February 15, 2024

**Re: Galles Chevrolet Parking at 2007 Candelaria Rd. NE & Motel Demo  
Erosion and Sediment Control Plan  
Engineer's Stamp Date 1/12/2024 (H15E007 & H15E029)**

Based upon the information provided in your submittal received on 2/8/24, the above-referenced ESC Plan is acceptable, but it cannot be approved for demolition and grading permits until the following comments have been addressed.

1- COVER

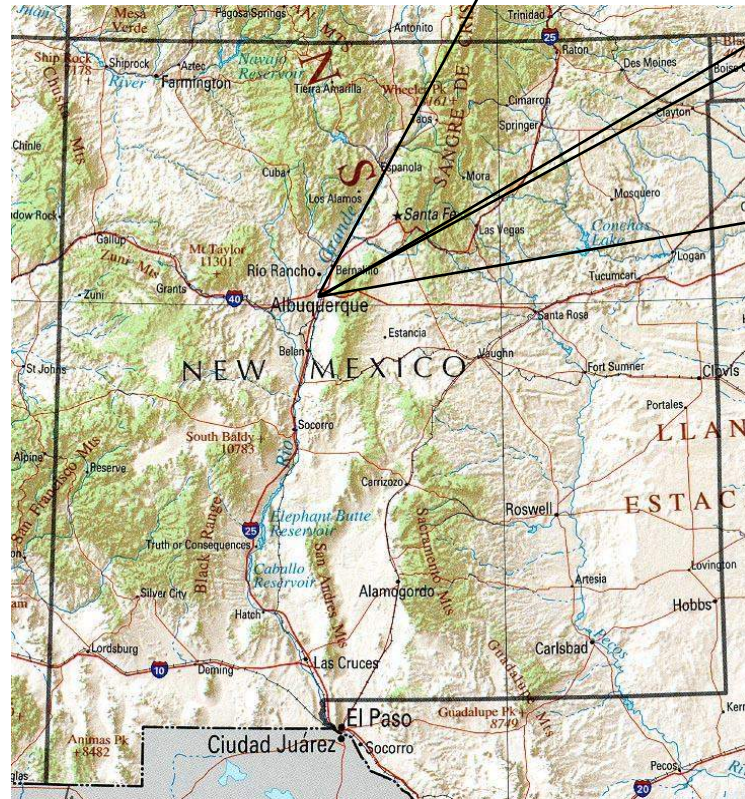
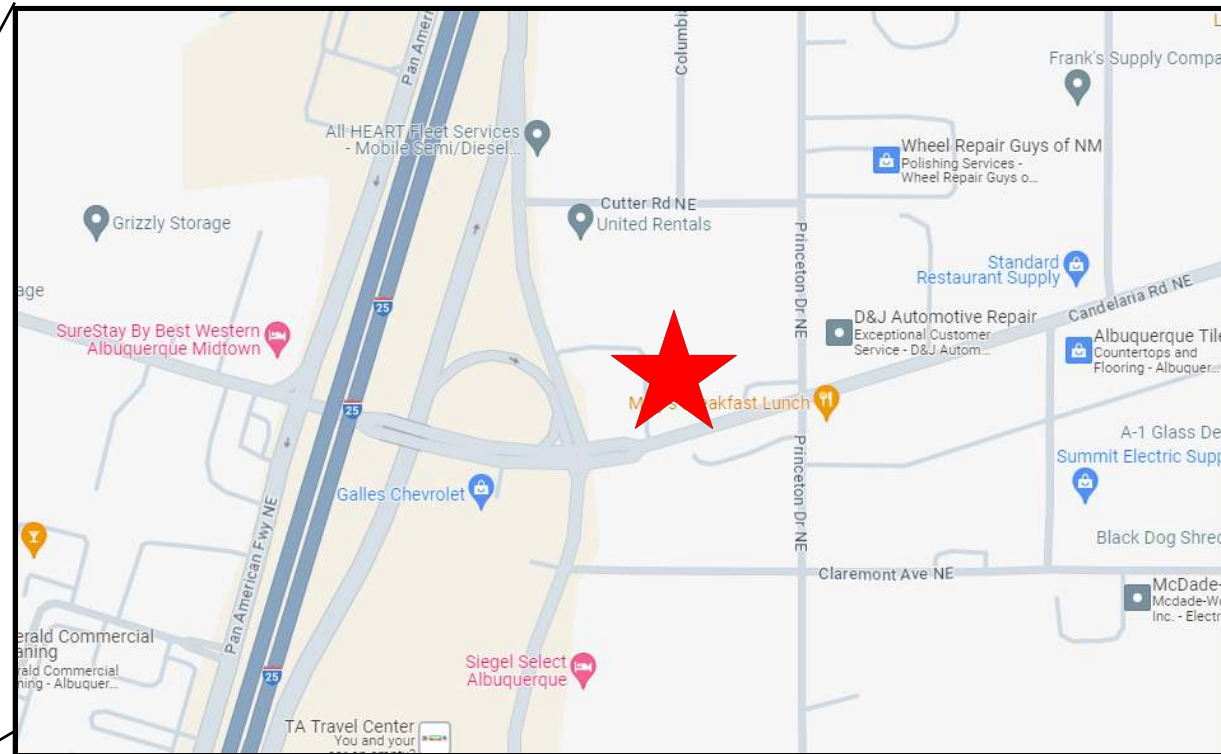
1. This 1.5-ac site, 2007 Candelaria Rd., is contiguous with the existing 1.1-ac site at 2001 Candelaria Rd., and both sites are being leased by Galles Chevrolet Inc., which makes both of these lots part of a "Common Plan of Development or Sale" as defined in Appendix A of the CGP. Include a list of all other operators who will be engaged in construction activities at the site and the areas of the site over which each operator has control per CGP 7.2.1.
2. Galles Chevrolet, Inc.'s existing NOI (NMR1005MK) and SWPPP must be updated to include both of the leased properties at 2001 and 2007 Candelaria Rd., totaling 2.6 acres, and an additional NOI is required for the owner of 2007 Candelaria Rd, BDP Inc.
